St Anthony of Padua Catholic School Redevelopment (SSD-8865)
Request for Additional Information

I refer to Response to Submissions (RtS) for the St Anthony of Padua Catholic School Redevelopment (SSD-8865). After careful consideration, the Department is requesting that you submit additional information that effectively addresses the issues identified in **Attachment 1**.

1 SITE PLAN - ROAD WIDENING WORKS
1 : 1000

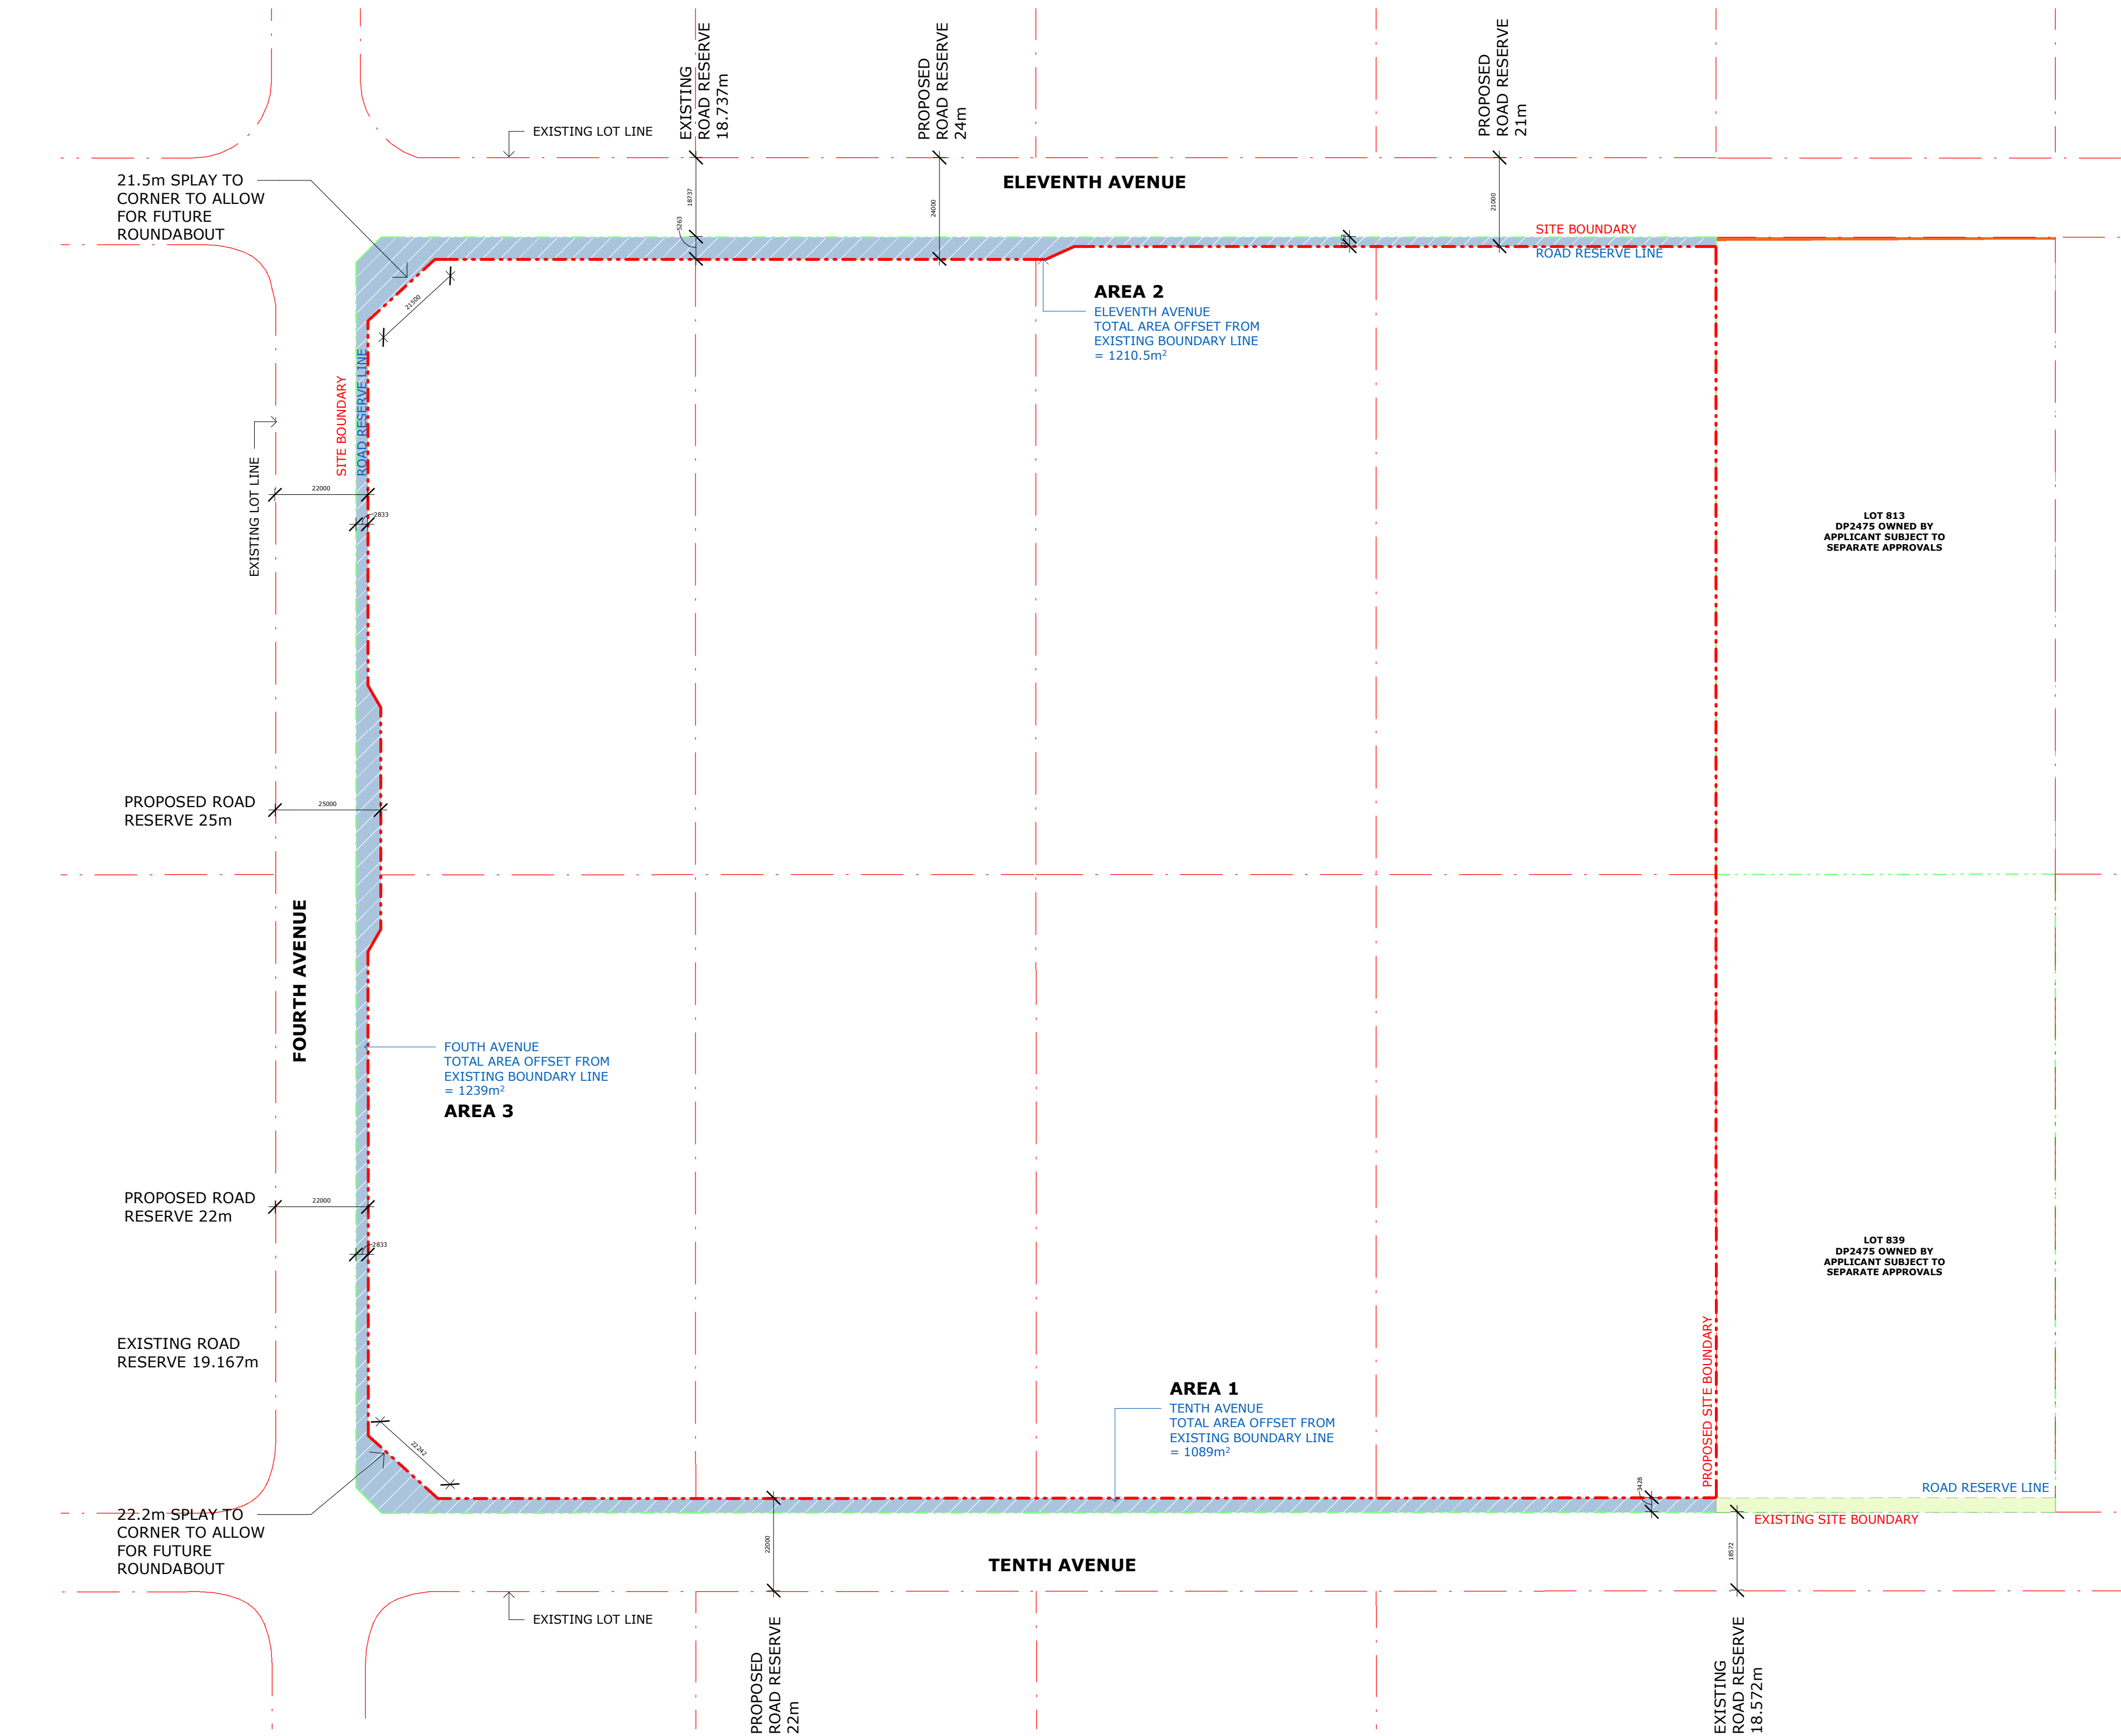
The RtS indicates that the proposed development includes road widening of Tenth Avenue, Eleventh Avenue and Fourth Avenue. While Eleventh Avenue is proposed to be fully widened, the civil plans show that Tenth Avenue and Fourth Avenue would only be widened for half of the width. The RtS does not clarify whether the remaining section would be widened as part of this proposal or at a later date. It also does not include reasons for not proposing the road widening for the full width of the road.
